PLANNING AMENDMENT

Application No. **H16/0515/98**
 Date Registered **30 OCT 1998**
 Case Officer **D. Gehay**

28 HOLBEACH ROAD, SPALDING.

**DEMOLISH 2 STOREY HOUSE
 IMPROVE FORECAST AREA
 VEHICULAR ACCESS, CONSTRUCT
 SMALL EXTENSION + CAR WASH**

CT/221/481

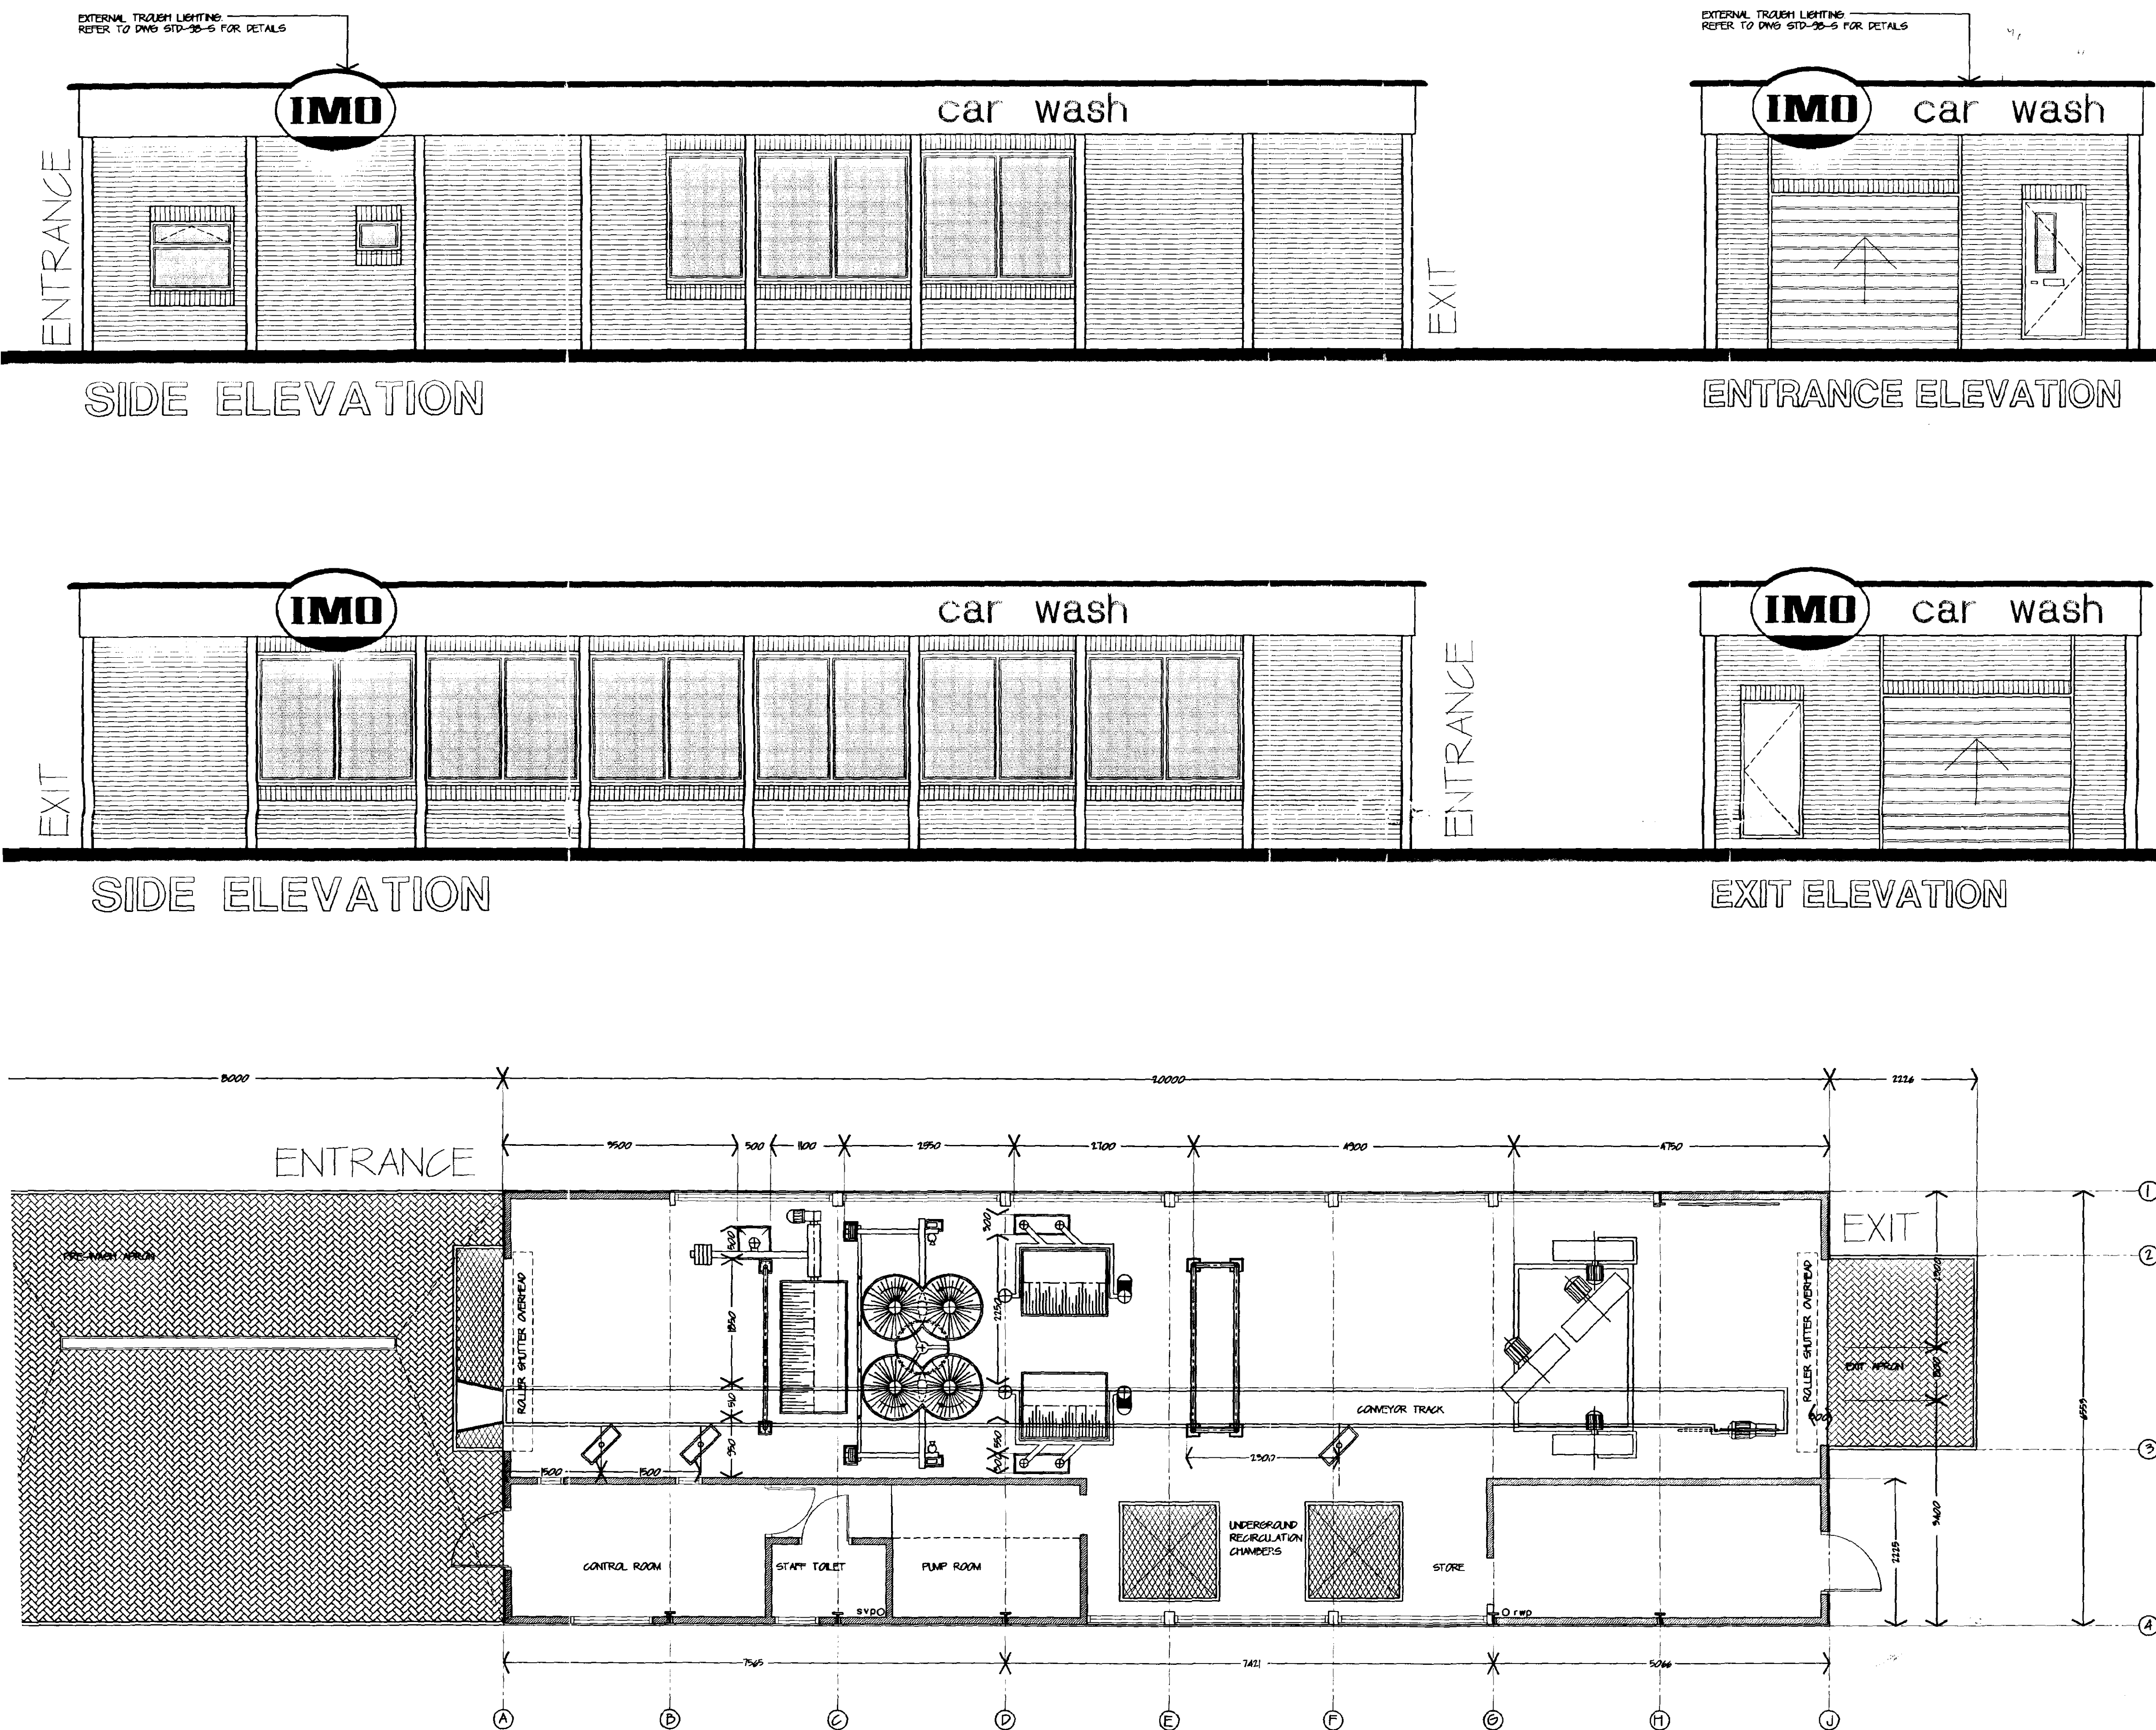
**RELOCATE POLF SIGN.
 REMOVE SPACES 1 & 4
 INCREASE RADIUS ON
 ENTRANCE AND EXIT
 RE COUNTY HIGHWAYS**

Amendment: Relocate pole sign, remove spaces 1 & 4, increase radius on
entrance & exit (Dwg no. CT/221/481 Rev C)
